## Application for a Non-Material Amendment Following a Grant of Planning Permission

Demolition of existing double garage block and rear conservatory and erection of two storey side extension, single storey rear extension. Removal of part existing roofs and proposed replacement part roof and alterations to windows at the rear.

DA/23/00064/VCON

Change from face brick on central area of front elevation (main entrance) of original dwelling to painted render.

04 PROPOSED FRONT ELEVATION
 1:100 @ A1

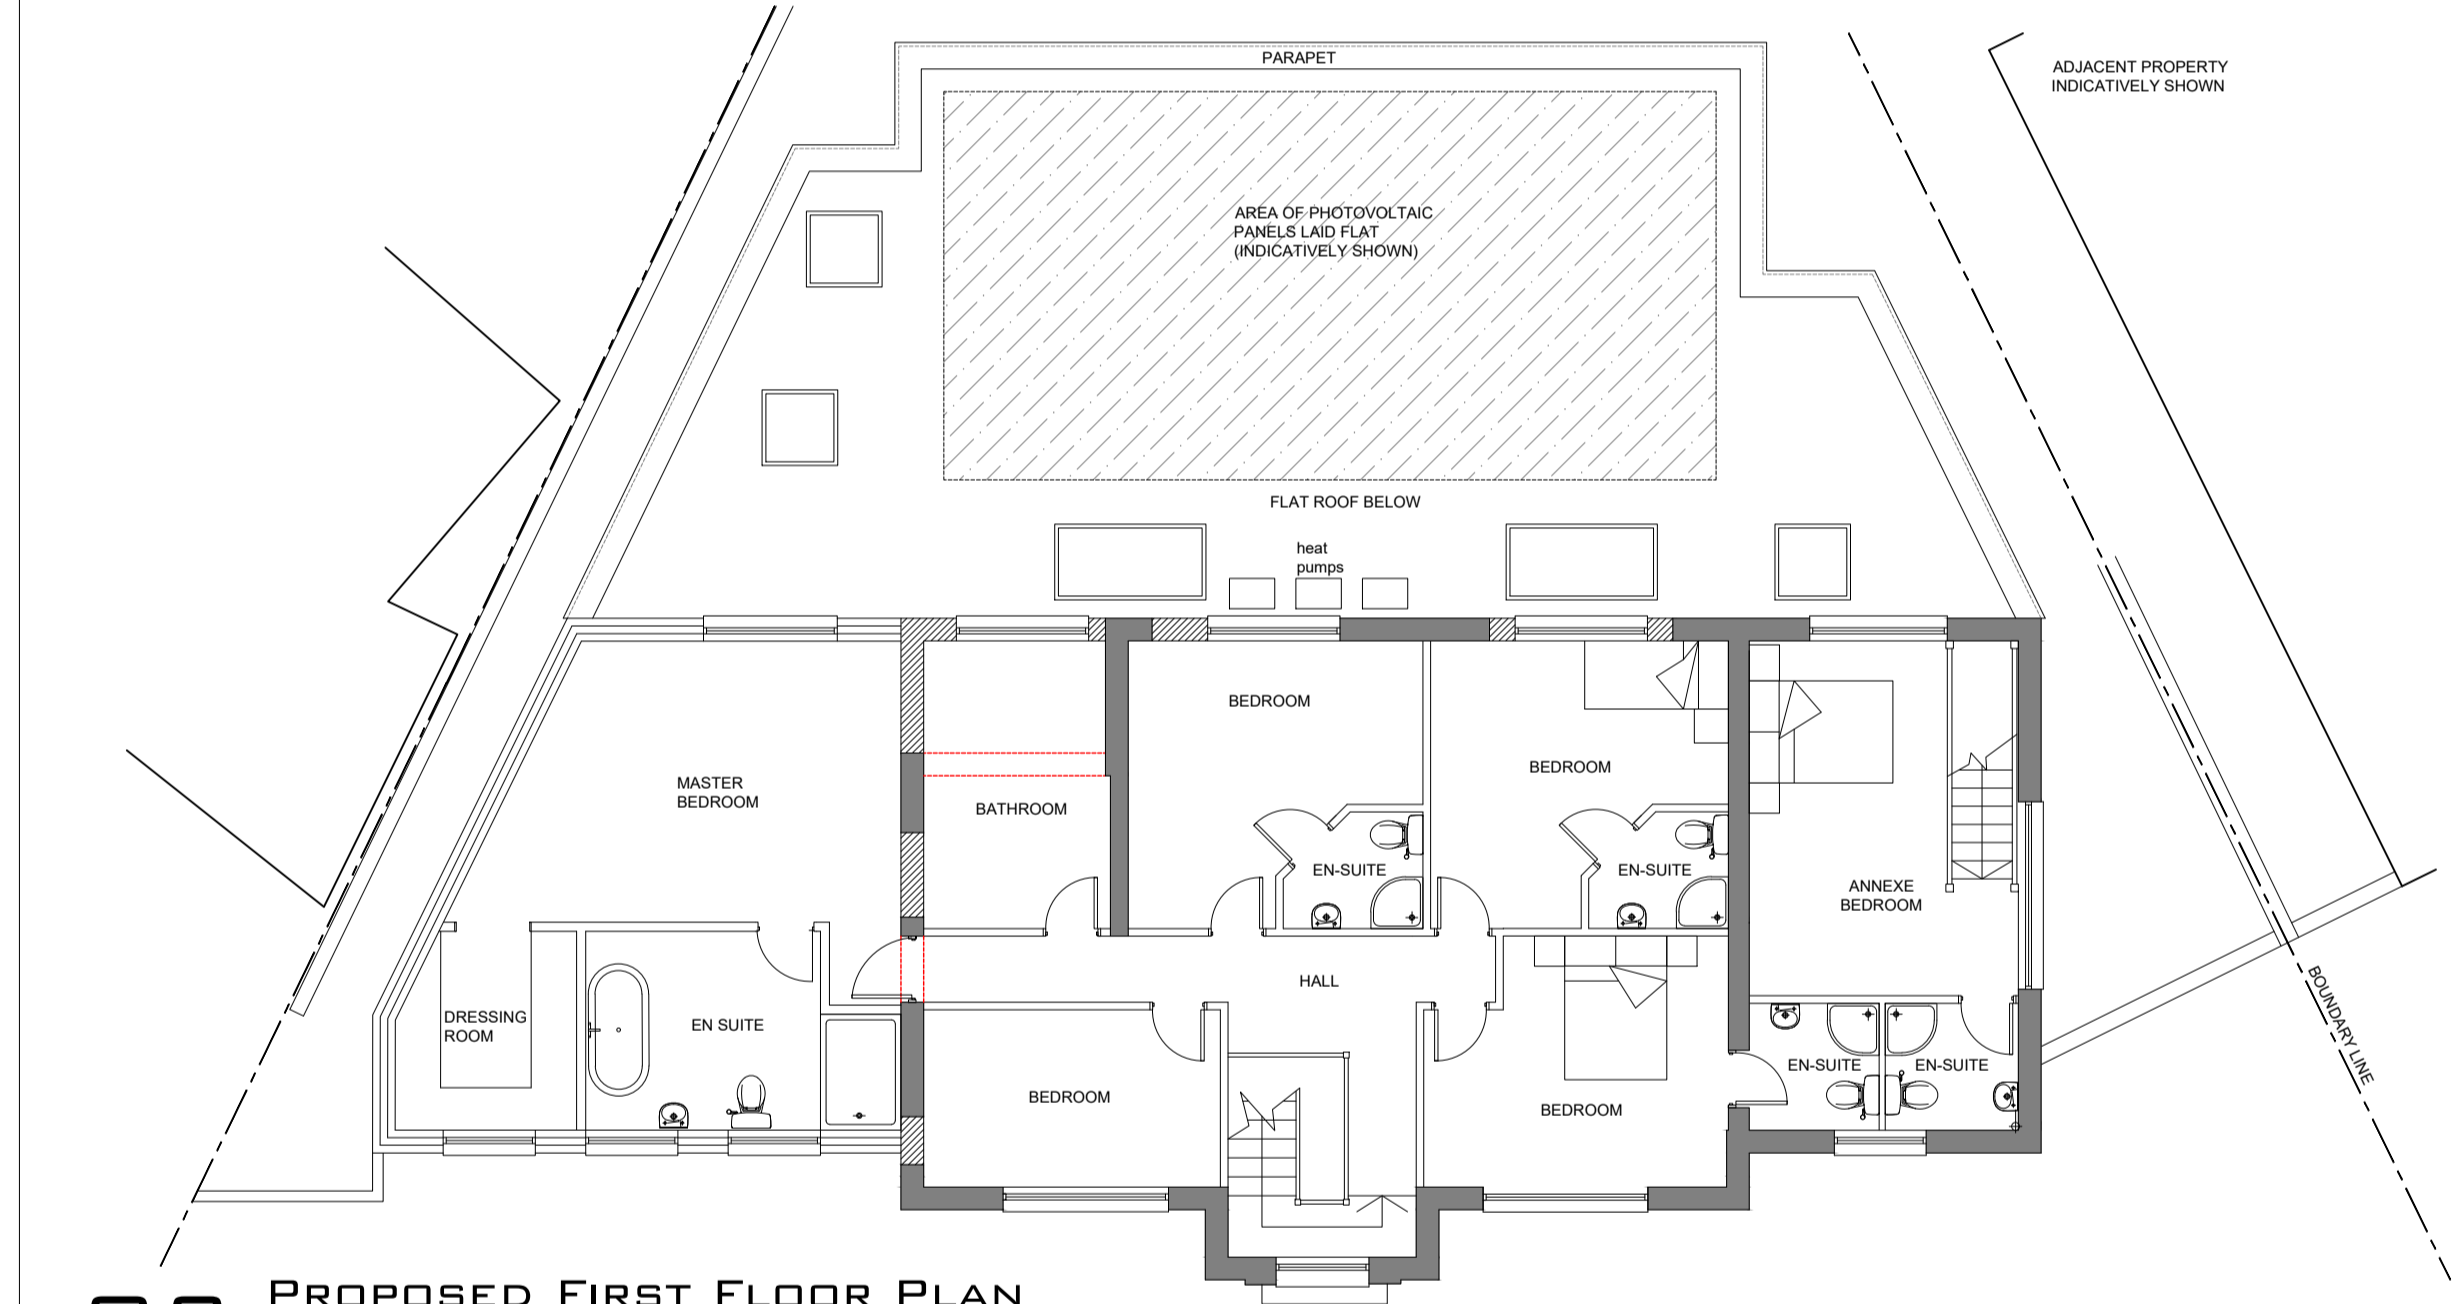
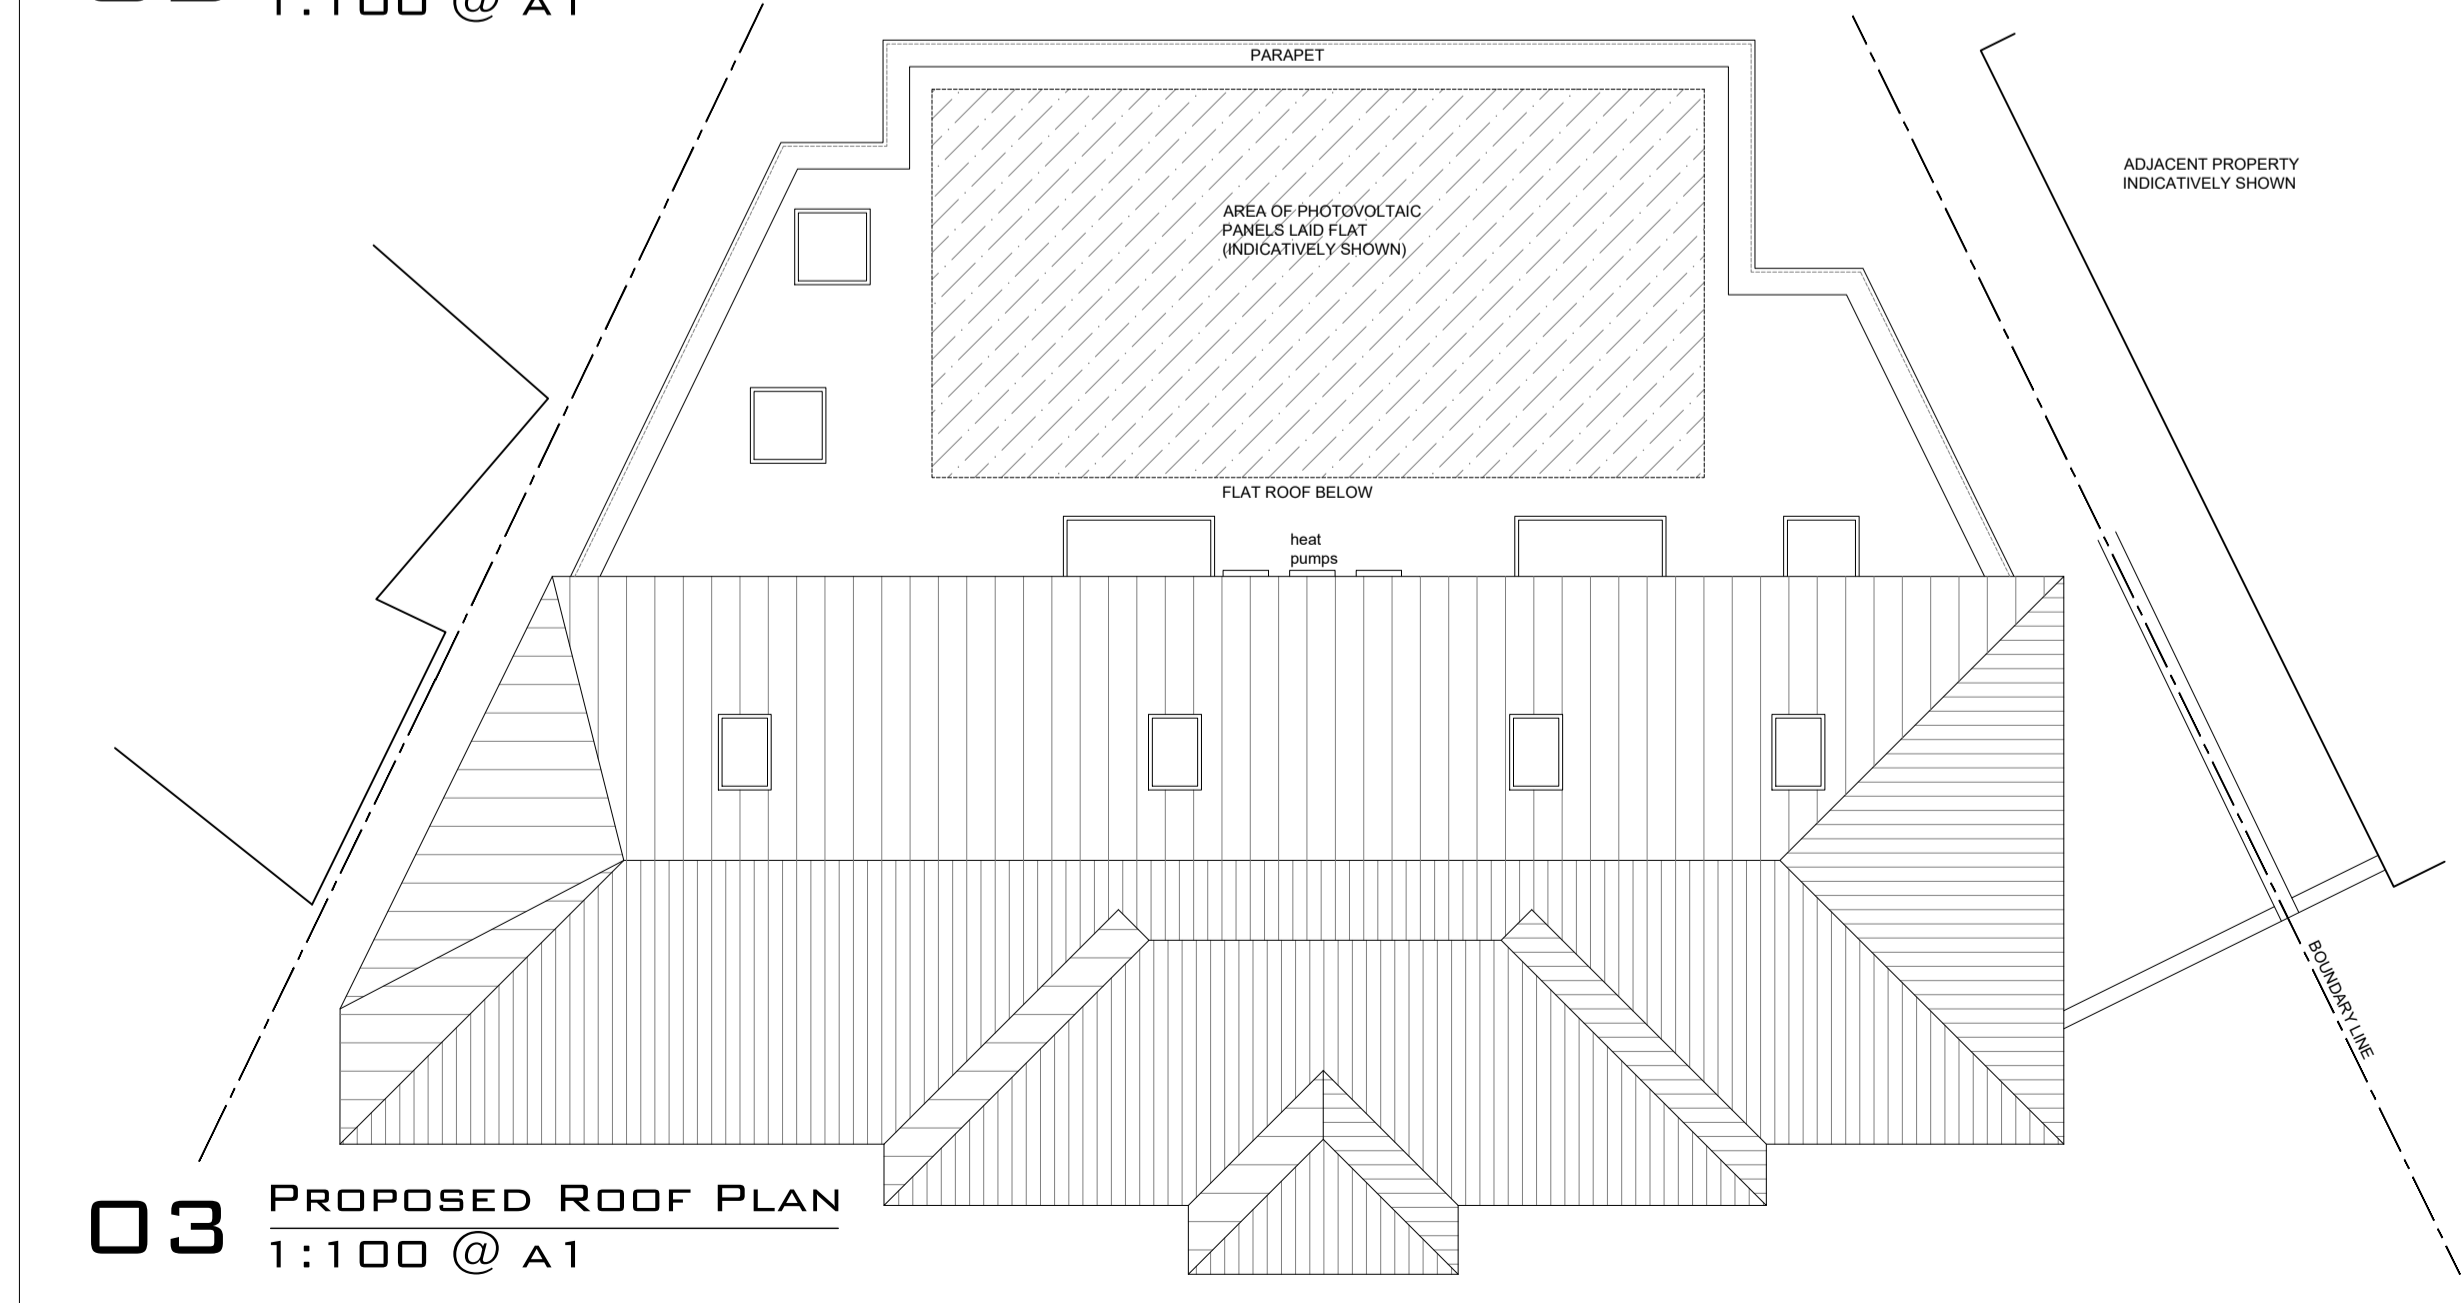
Aesthetics and the proposed changes have come about due to the issues matching the existing bricks in terms of type, colour and size from imperial to metric.

Drawing 21015-A103\_P rev P11
